Engineers Comments Regarding Surface Water Drainage

Application Reference:	WA/108/24/PL	Reviewer Reference:	ADC/SB
Planning Officer:	Amber Willard	Date of Review:	12/09/2025
Site Name:	Stoneybrook Farm Eastergate Lane Walberton BN18 0BA		
Application Description:	Erection of a re-purposed building for use as Class E (g) (iii) floor space, access, parking, drainage and landscaping. This application is in CIL Zone 3 (Zero Rated) as other development.		
Assessment Number:	3 of 1

Response	No objection subject to condition and change to block plan
-----------------	---

Scheme as approved under ref.s
APPC3810/W23/3316638
WA8722/PL

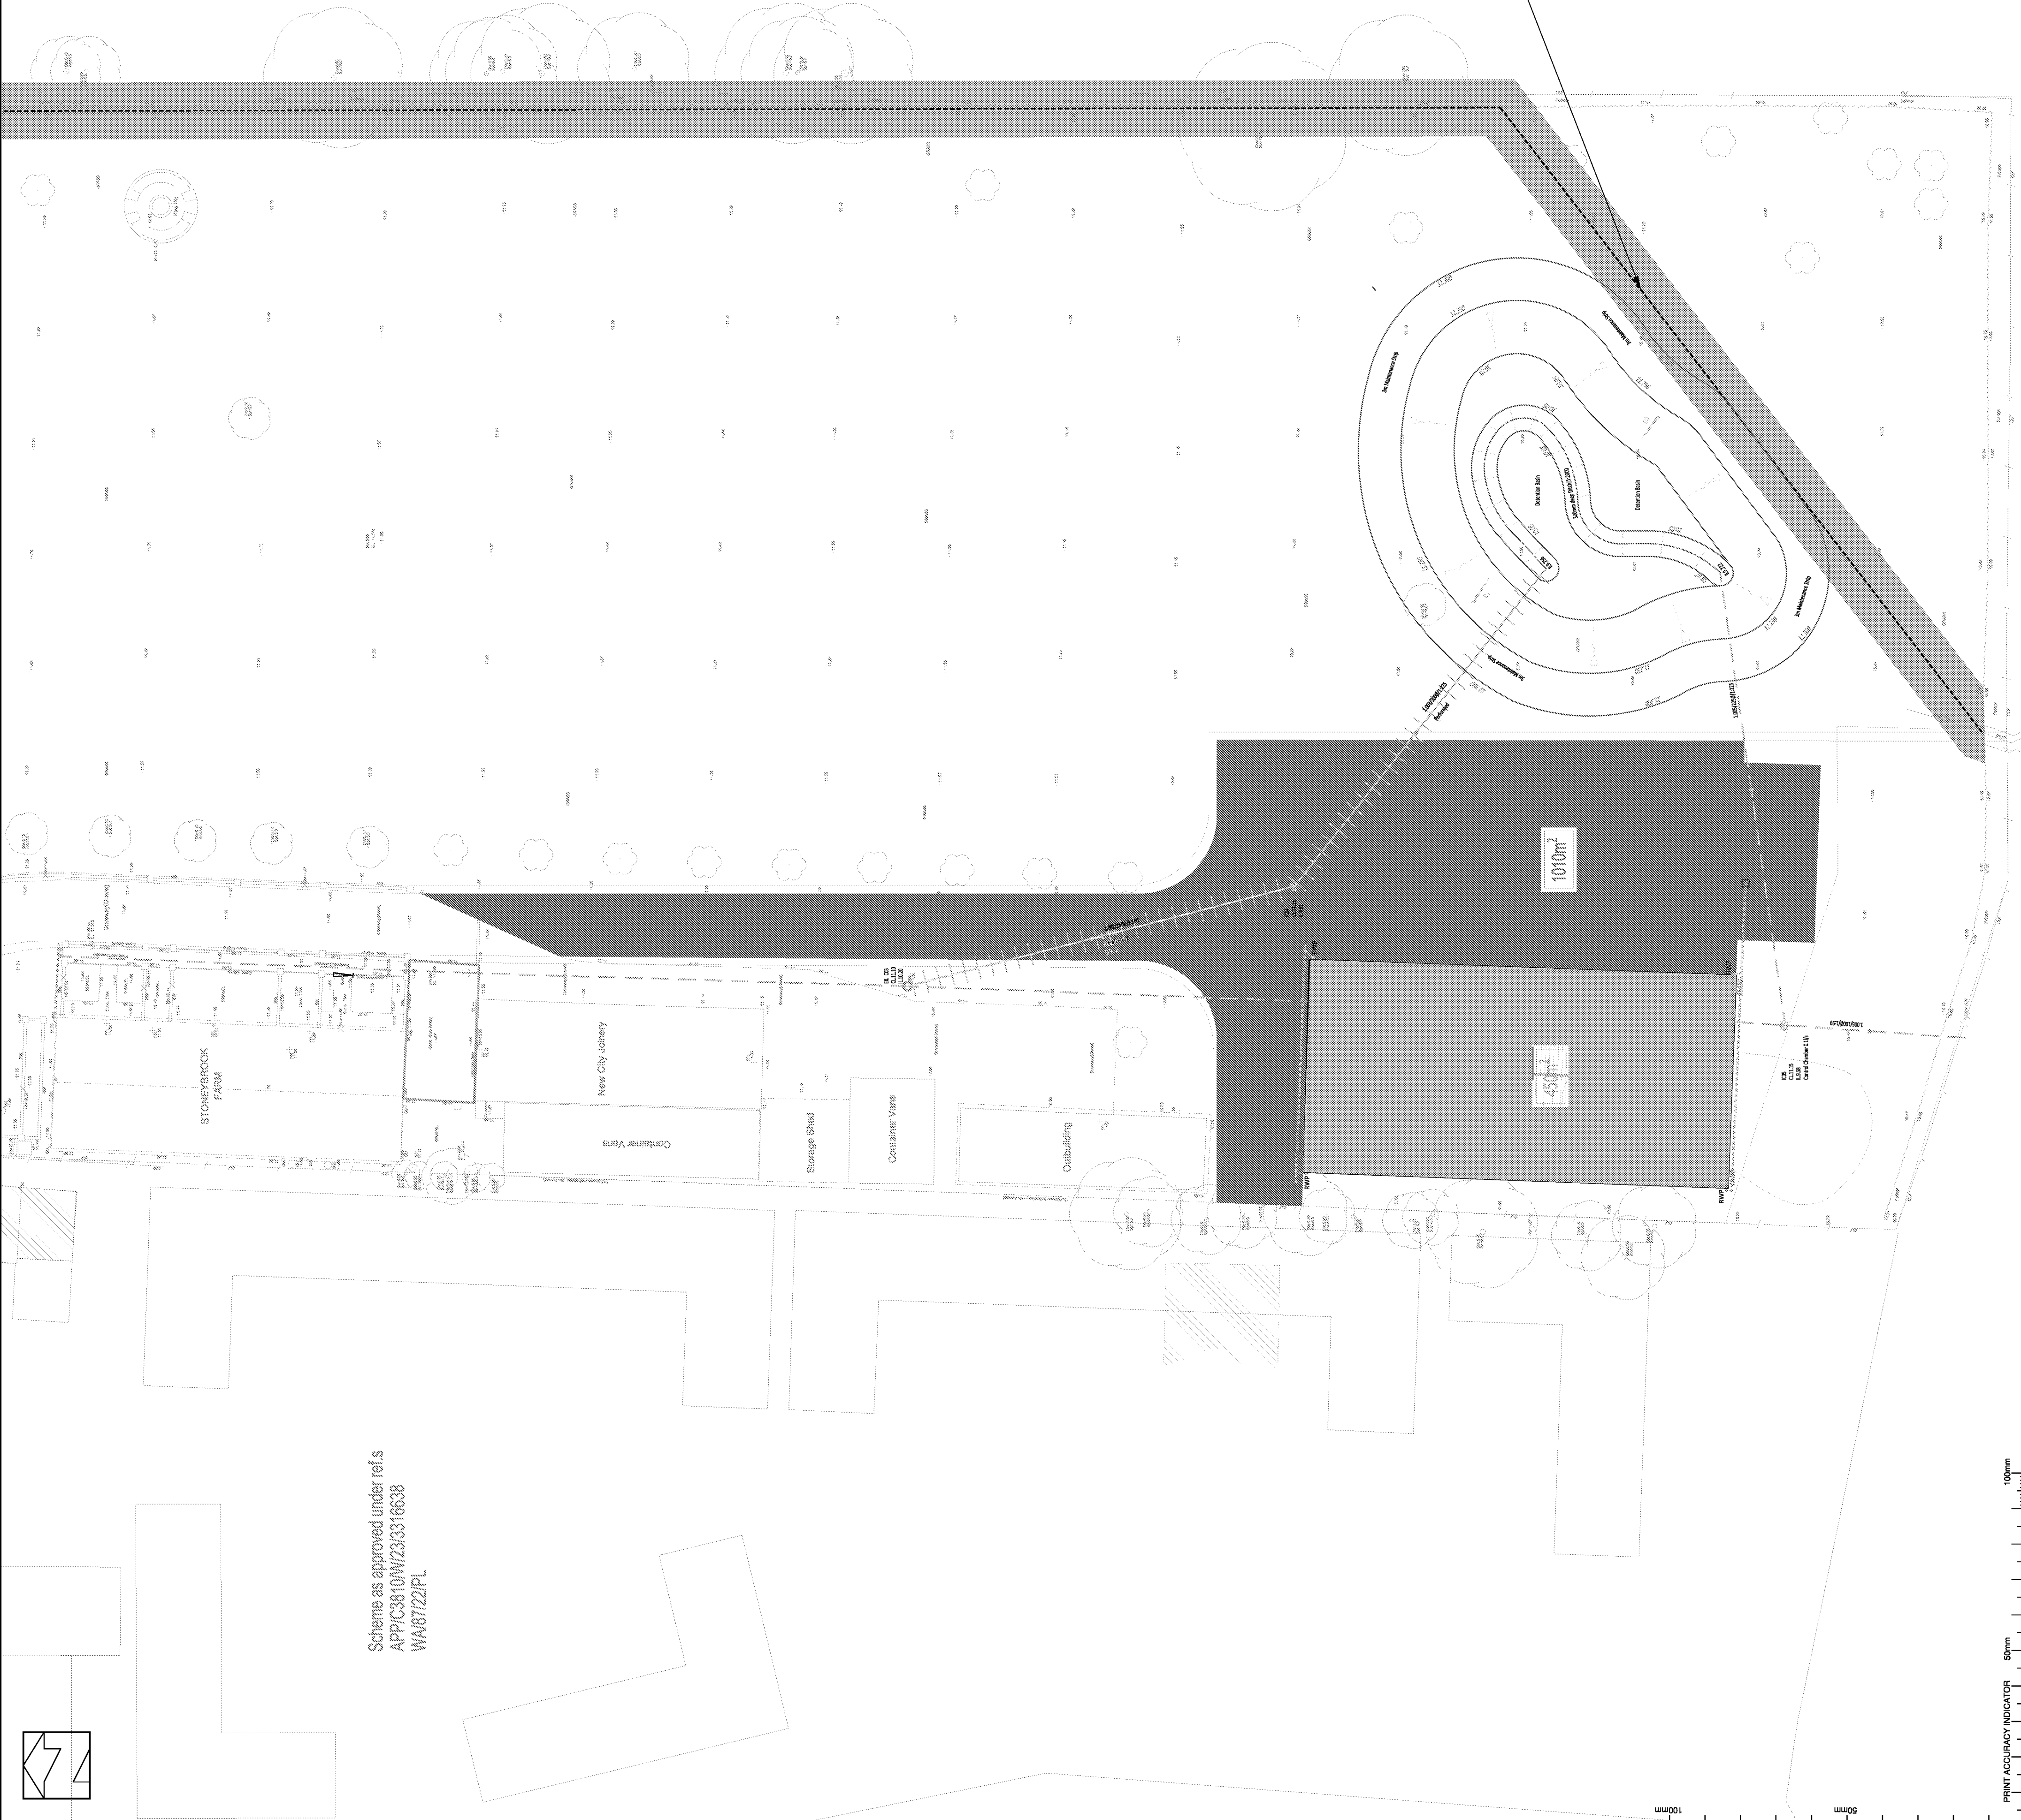
- A001-013/101 Rev B – Proposed Surface Water Drainage. Referred to as the **Drainage Layout (superseded)**.

It is unclear if there may be infiltration potential on the site. This is because the designer has relied on site investigations from a neighbouring site. Infiltration tests must be completed in winter, at the proposed location, depth and head of water that any infiltration structure is proposed. The tests (and feature) must be at least 1m above the peak recorded groundwater level to provide adequate depth of unsaturated ground.

This means that the designer must have an accurate understanding of the groundwater levels. The proposed design relies on assumptions regarding the groundwater level based on the difference between the cover levels between this and the neighbouring site. This introduces an unacceptable level of uncertainty. It is likely that groundwater will be high enough that infiltration will not be a viable means of surface water disposal, even for a hybrid system (as proposed), due to the risk of groundwater entering the system during the lifetime of the development. However, this must be evidenced prior to approval of the drainage design.

There is an existing tree within the maintenance easement of the pond as drawn. The future growth potential of the tree will need to be considered, and the boundary of the pond (and liner) adjusted to account for this. The designer is also aware of the potential root damage caused by an existing tree close to the outfall. This shall be surveyed and remediated as necessary prior to commencement.
